**Memorandum  
 Planning and Urban Development Department  
 Planning Division**

**To:** Carol Morrissette, Chair and Members of the Portland Planning Board  
**From:** Jean Fraser, Planner  
**Date:** December 14, 2012  
**Re:** Mixed Use Development at 321 Commercial Street; Level III Site Plan/Subdivision, J B Brown & Sons, Applicant.  
**Project #:** 2012-615      **CBL:** 40-E-3  
**Meeting Date:** December 18, 2012

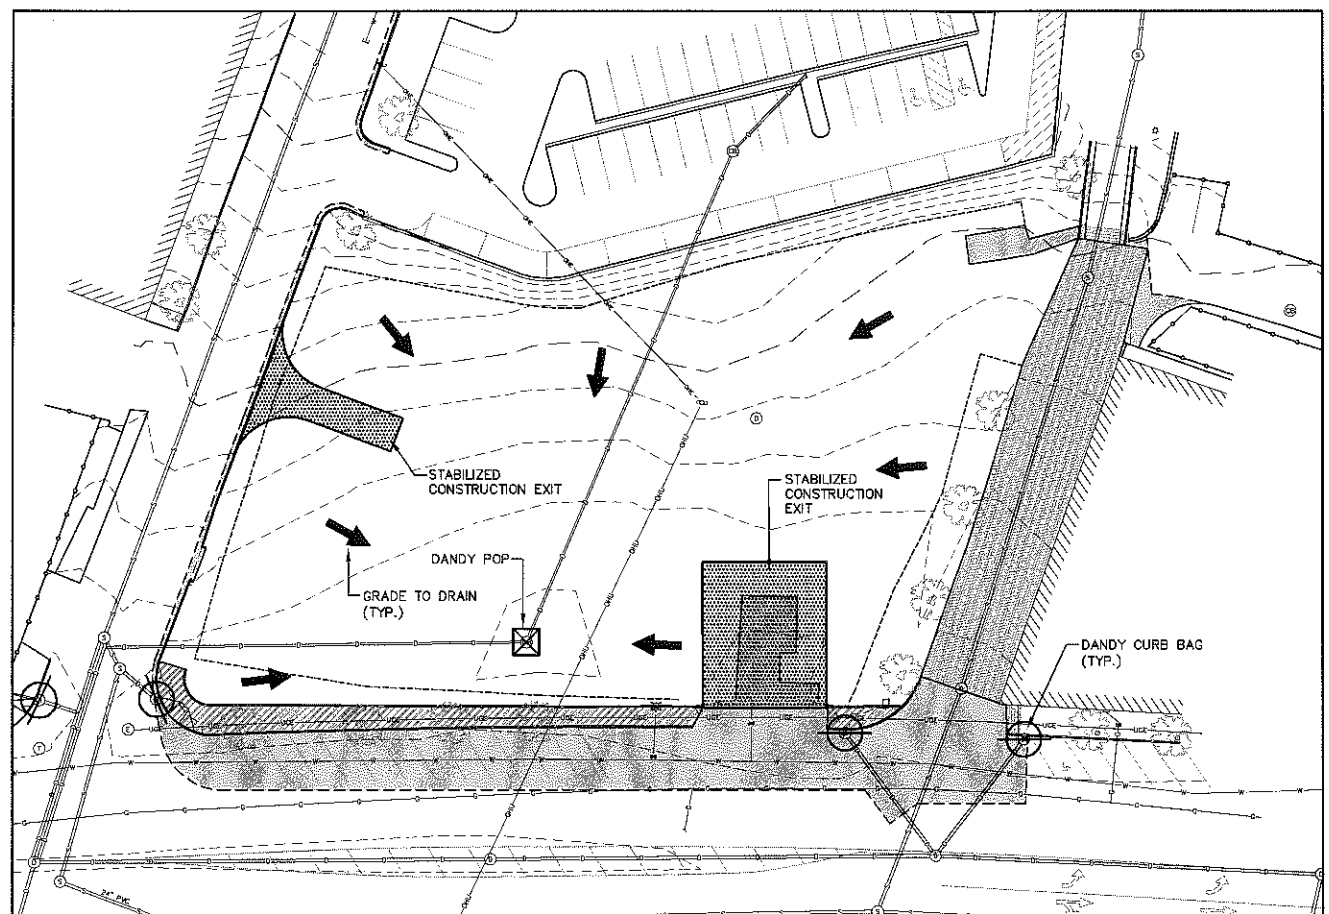
The applicant has responded by adding one stormwater treatment area (bio retention cell) within the bump out at the Commercial Street site entrance (near Foundry Lane- as shown in Attachment R and in the Foundry Lane conceptual plan ( Plan 21). Reviewers have commented that this is acceptable subject to reviewing supporting calculations and design details (Attachment 14 and 16).
